CITY OF ALBUQUERQUE

February 17, 2023

RE: Modwash - Eubank
Grading & Drainage Plans
Engineer's Stamp Date: 02/07/23
Hydrology File: K20D060

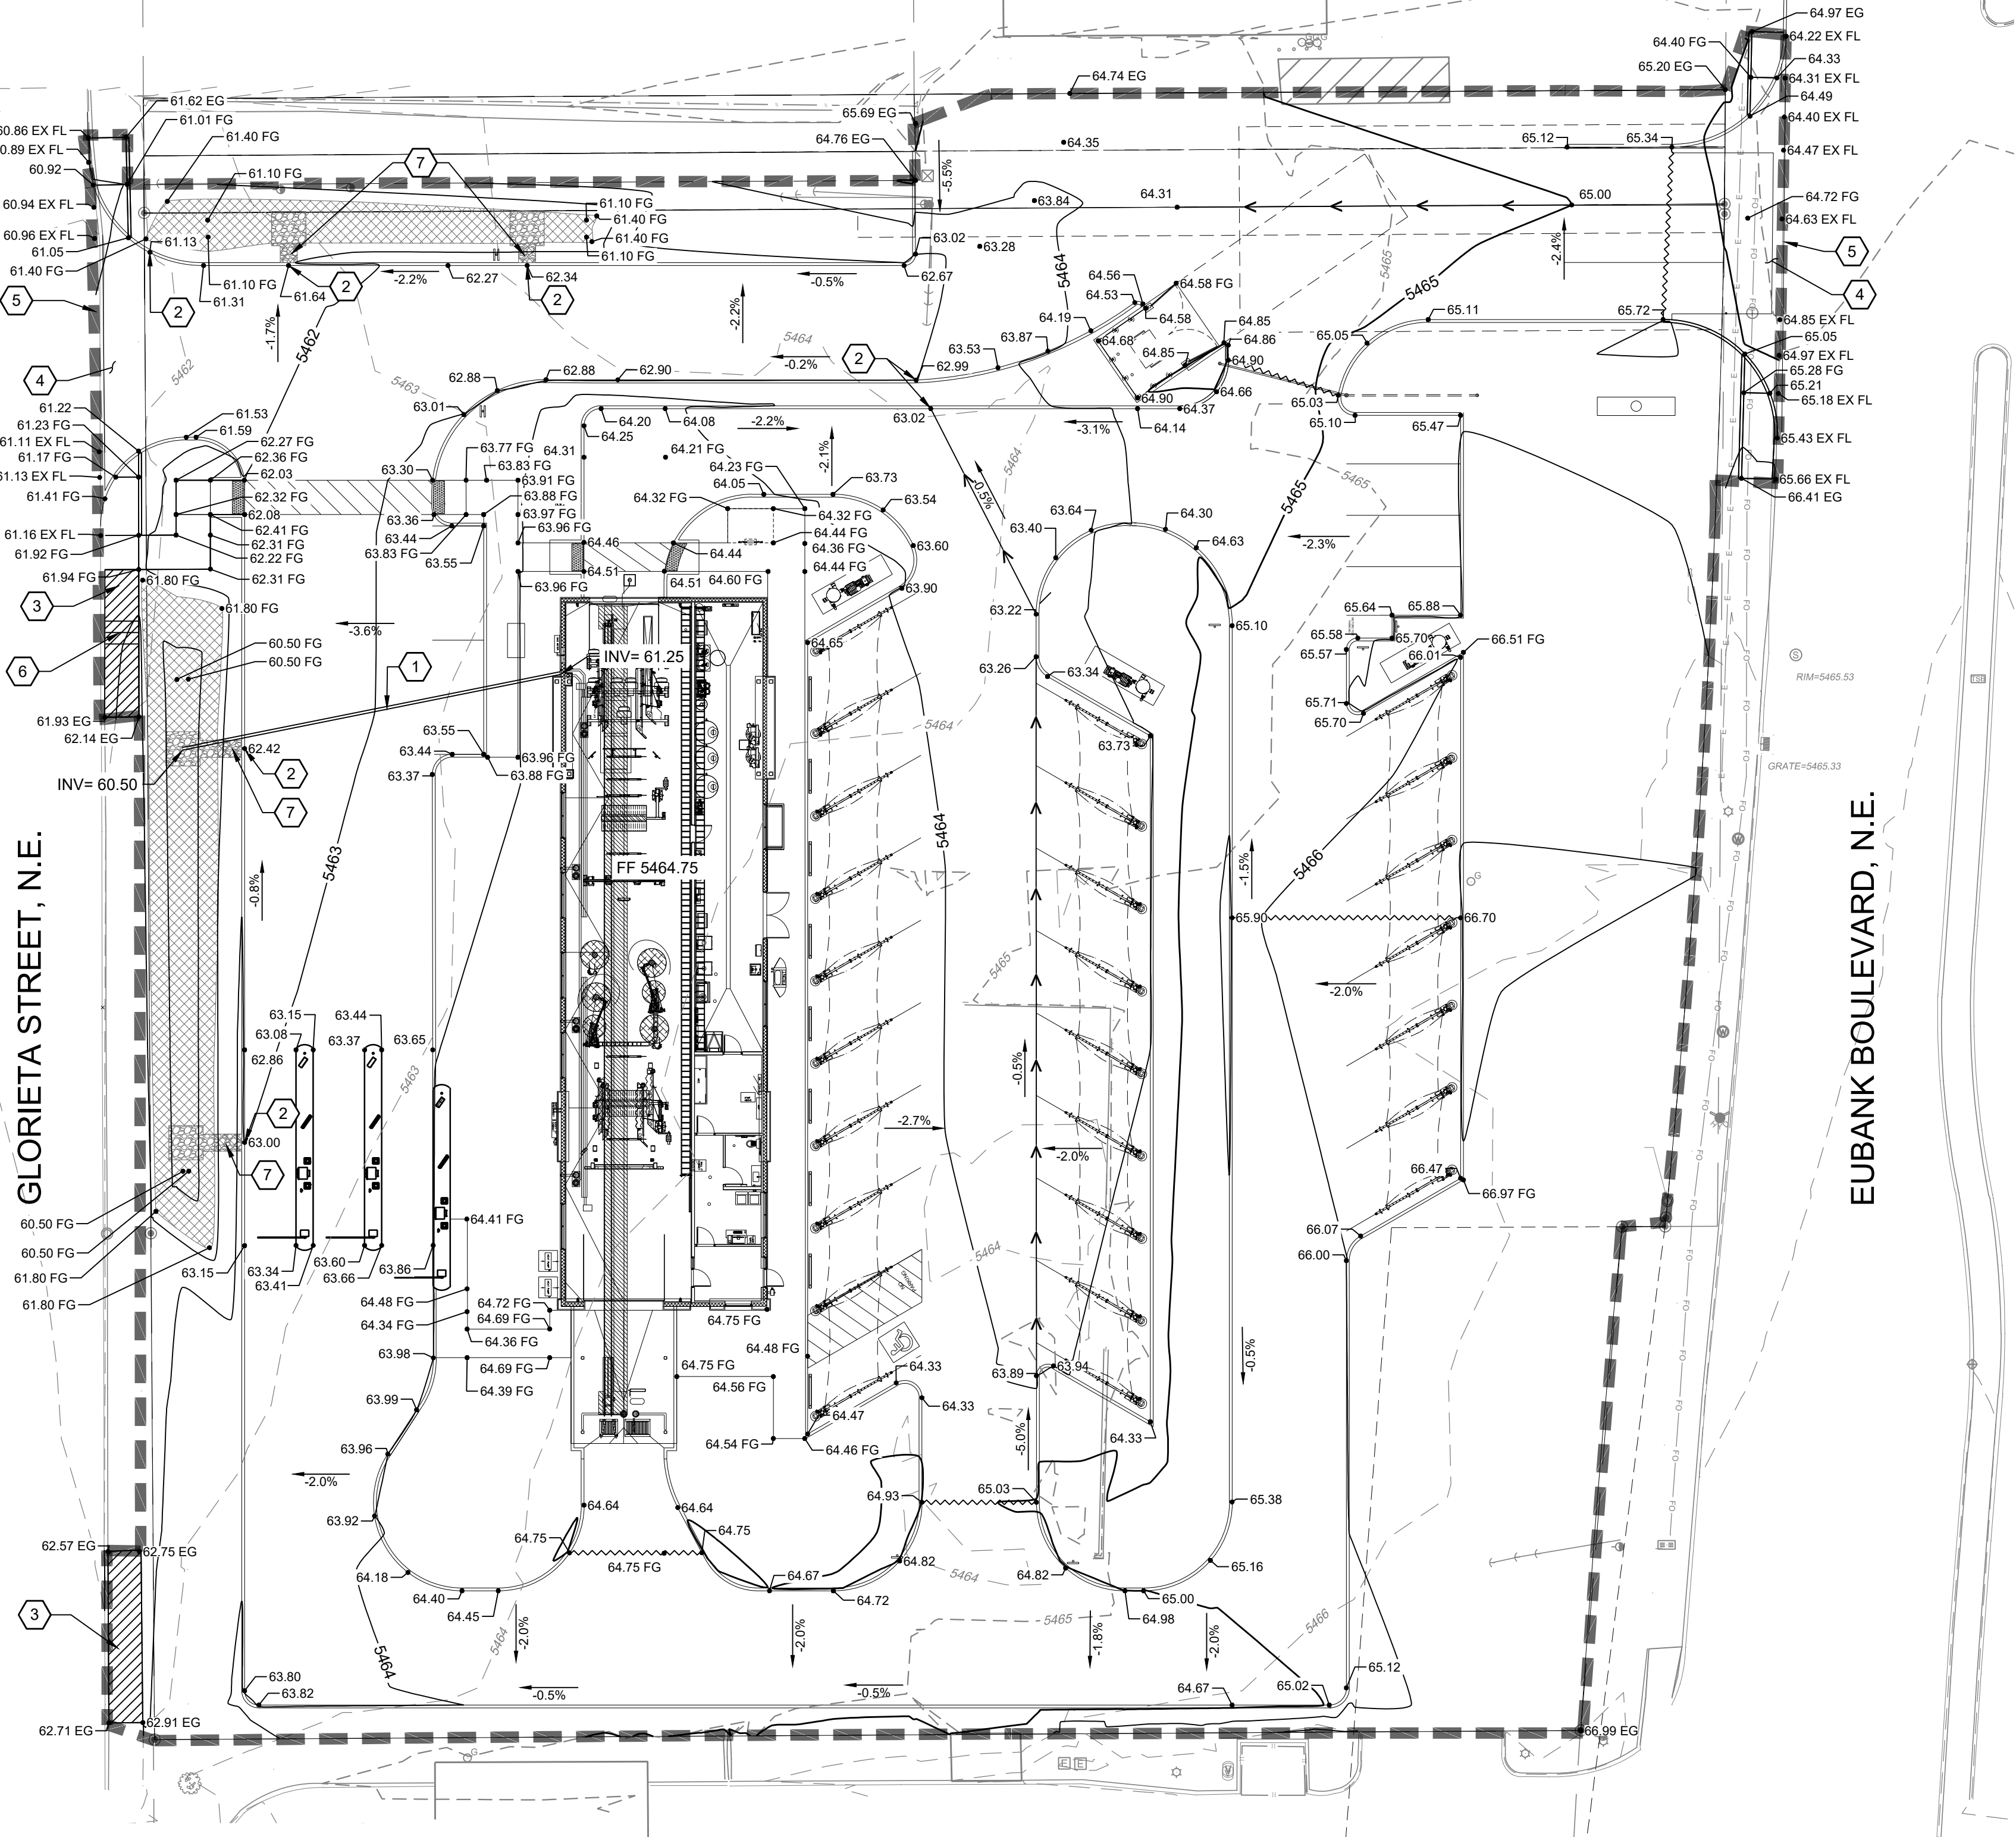
2. On Sheet C-103, Please insure that the drainage flow arrows match the drainage flow arrows on Sheet C-104. There are a few that do not match.
3. Since there is curb & gutter on the project, please remove the existing drive pad on Eubank and provide a private curb return per CoA Detail 2426.

6. On Sheet 104, please specify the curb cut width in Key Note #2.
7. On Sheet 104, please provide a sidewalk culvert for the spillway for the stormwater quality pond along Glorieta St. and label per CoA Detail 2236.
8. On Sheet 104, please provide the SO-19 Standard Notes, latest version.
